Submission Form**Epping to Thornleigh Third Track Proposal.** Application number SSI 5132.Name(s): WILLIAM CROSBY & JANET CROSBYAddress: 21 MALTON ROAD BEECROFT 2119

I/we object to the Epping to Thornleigh Third Track Proposal and consider that the EIS is inadequate and does not address the full impact of this proposal. It will cause untold damage to the health of residents and to the fabric of the Beecroft Cheltenham Heritage Conservation Area. Do not approve this project, reconsider the alternatives and protect the community.

Figure 5.5 Artist's impression of new elevated concourse at Cheltenham Station looking south from The Crescent (indicated circle)

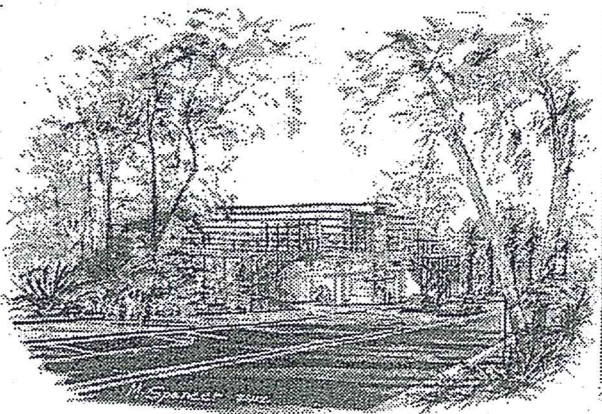
- The proposed redevelopment of Cheltenham Station shows no regard for the HCA. The visual impact of the proposed 13m high glass and steel concourse is totally unacceptable in this HCA.
